APPENDIX D RECOMMENDED CHANGES TO CONDITIONS

- A13. Prior to the lodgement of the first Future Development Application, the Applicant shall revise the Sydney Metro Martin Place Station Precinct Consolidated Design Guidelines (dated September 2017), to the satisfaction of the Secretary, as follows:

Stage 2 SSD DA Shadow Study - South Tower: Hyde Park

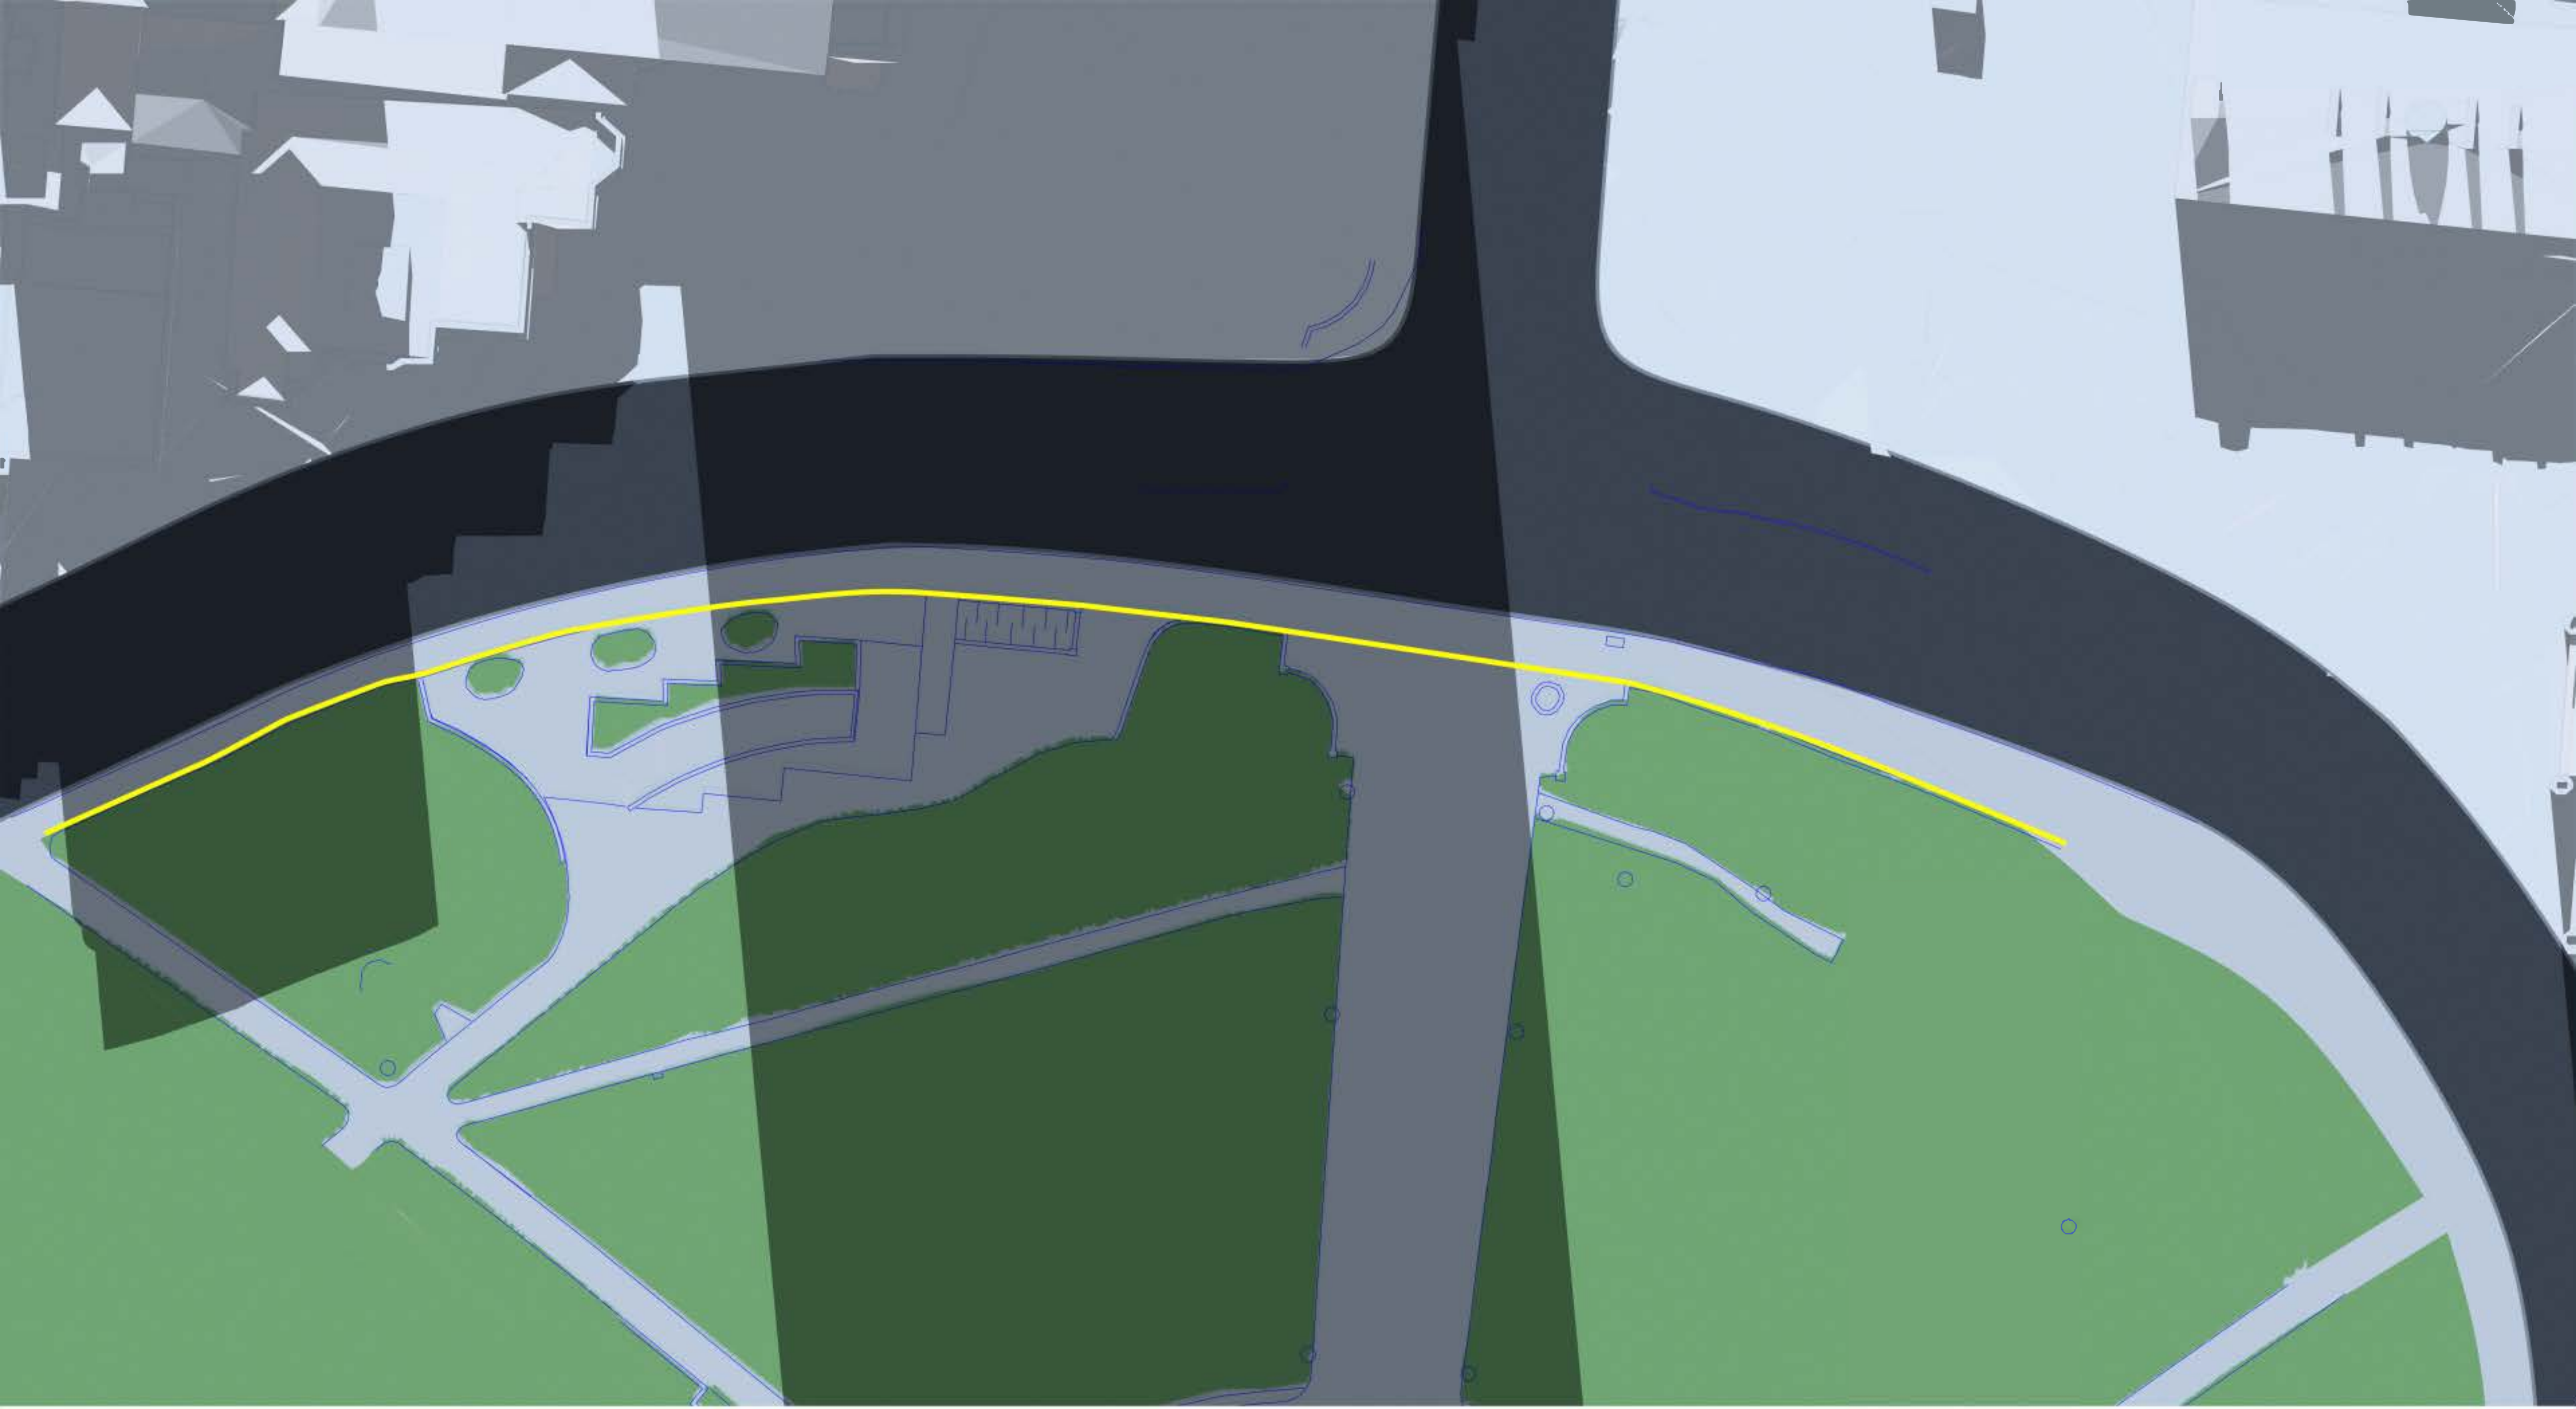
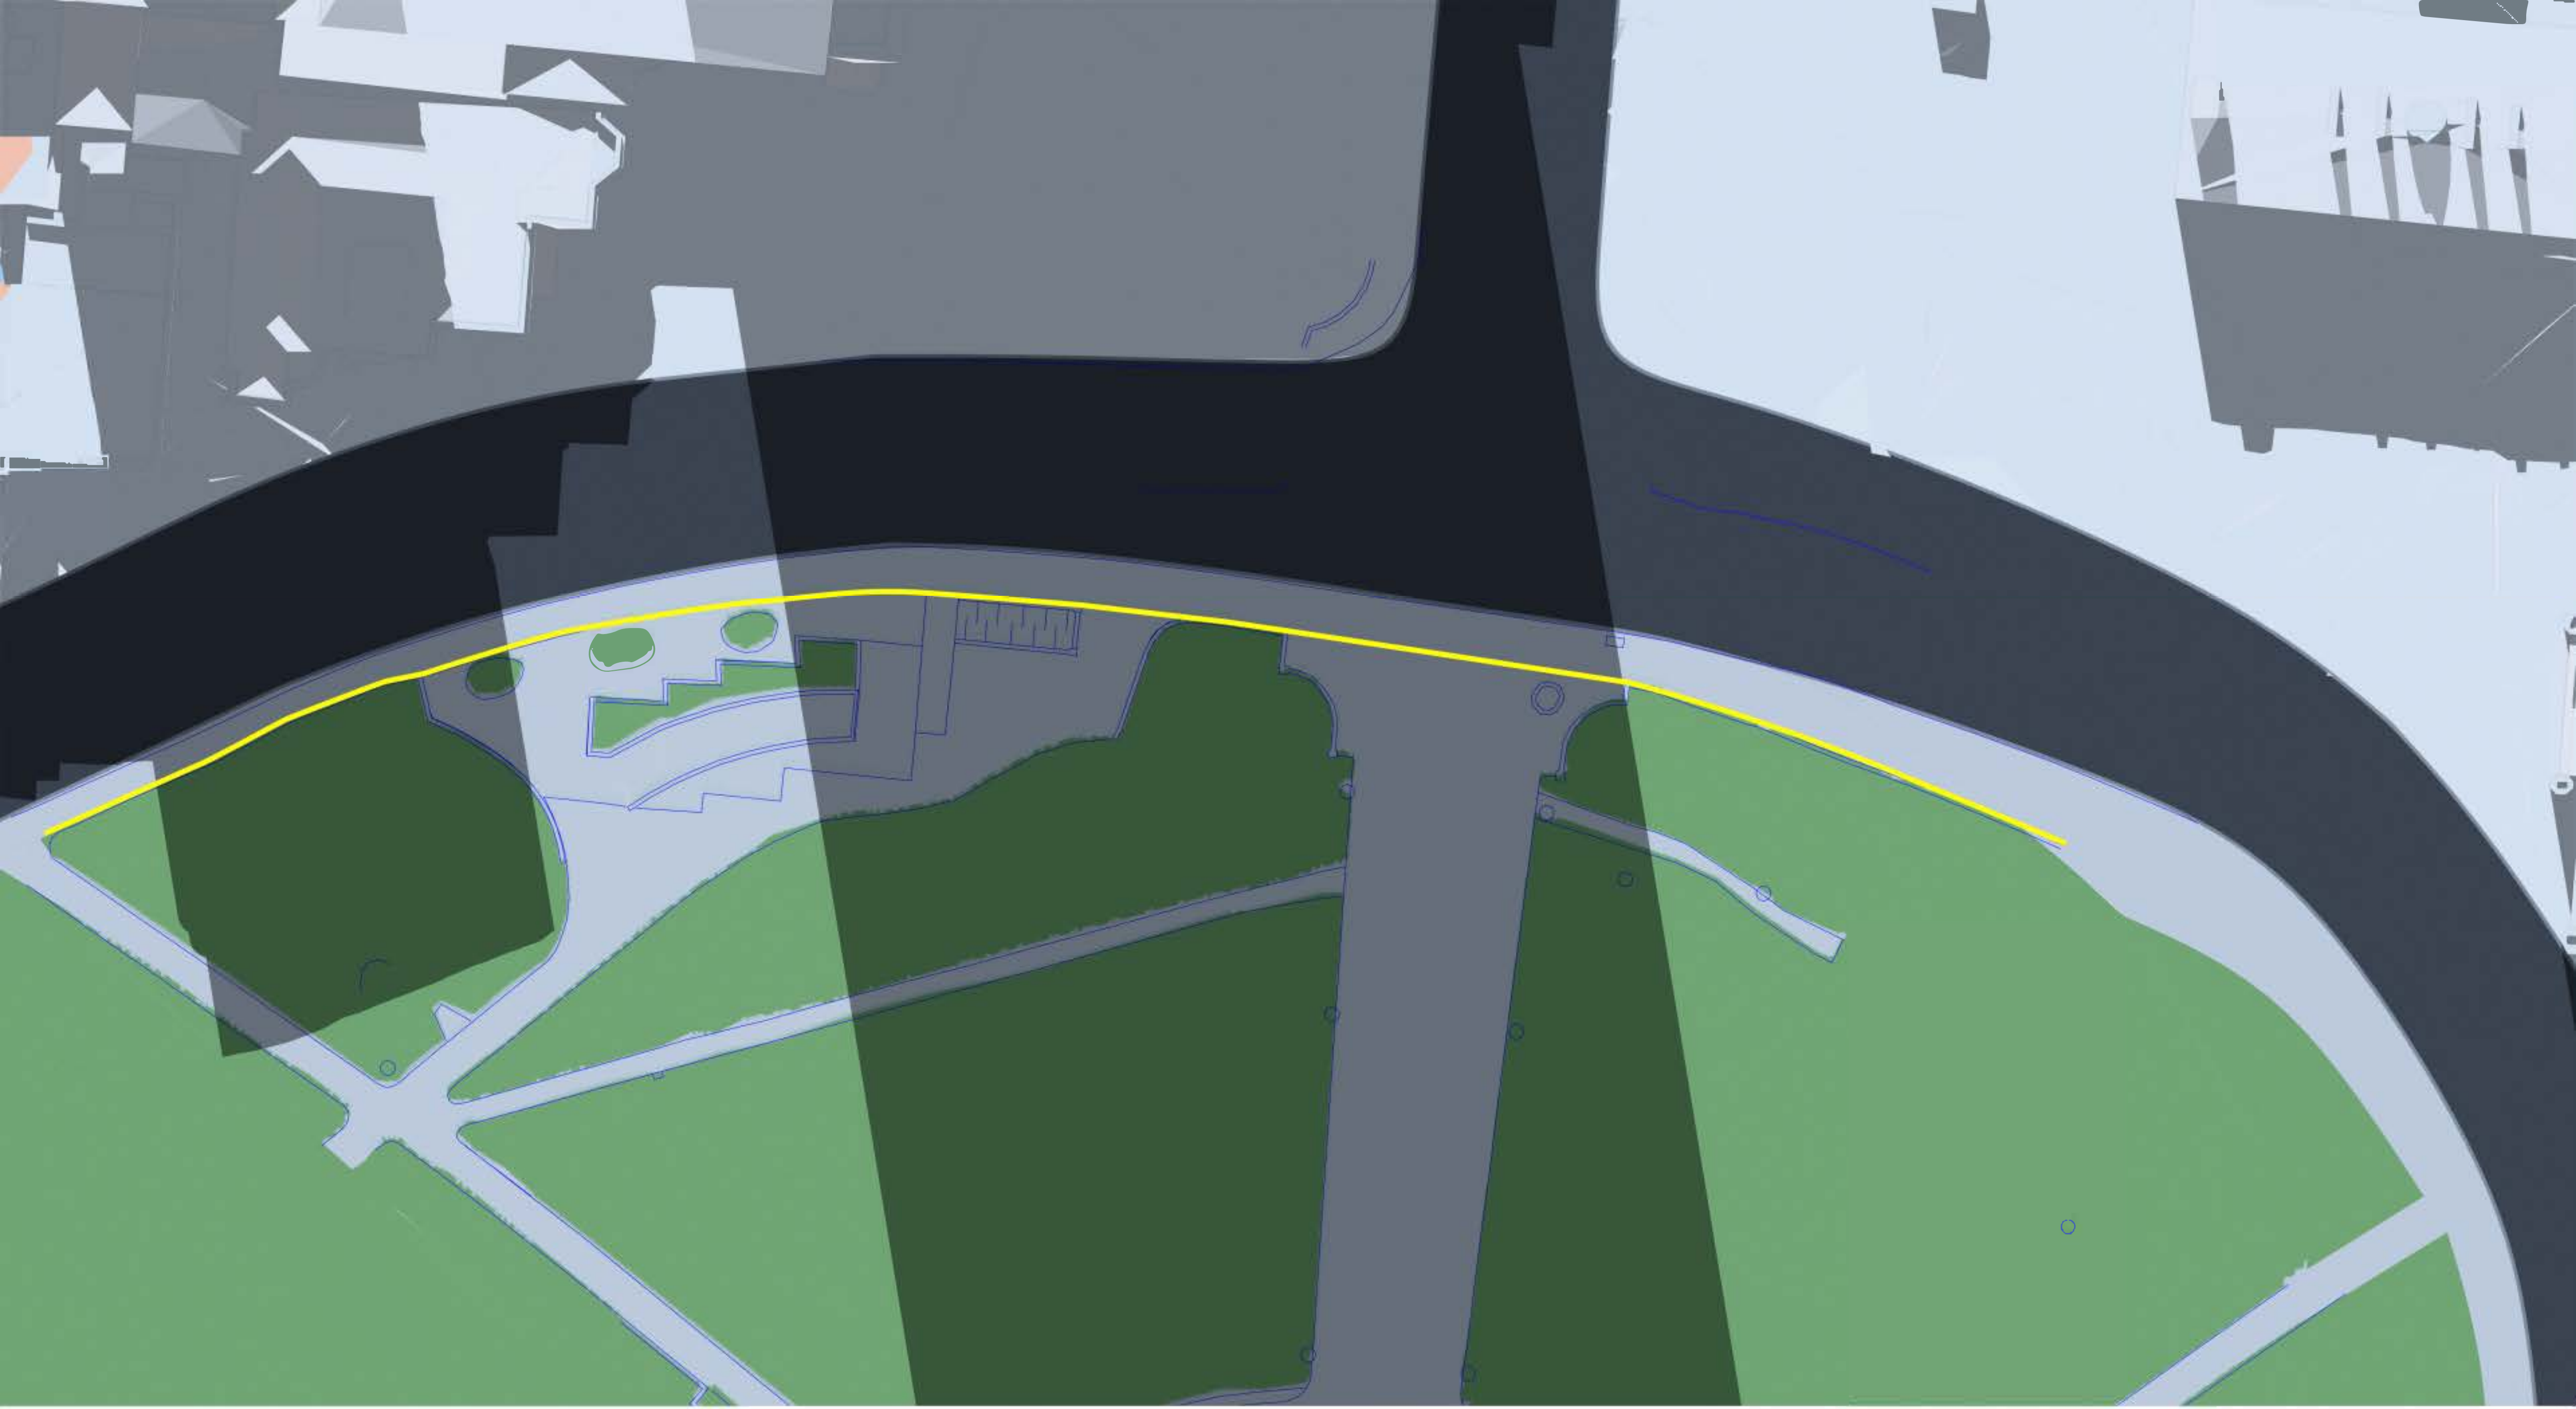
- b. In 2.2 (Public Domain): Add new **Guideline 3: Buildings on the North and South Sites shall:**
 - not result in additional overshadowing of Hyde Park between the hours of 12 and 2 pm at mid-winter (21 June), when compared to the shadow cast by existing buildings, approved buildings and the DCP/LEP compliant envelope set out in Appendix C of the Response to Submissions, titled SSDA Addendum Shadow Analysis, prepared by Grimshaw and Johnson Pilton Walker, dated August 2017
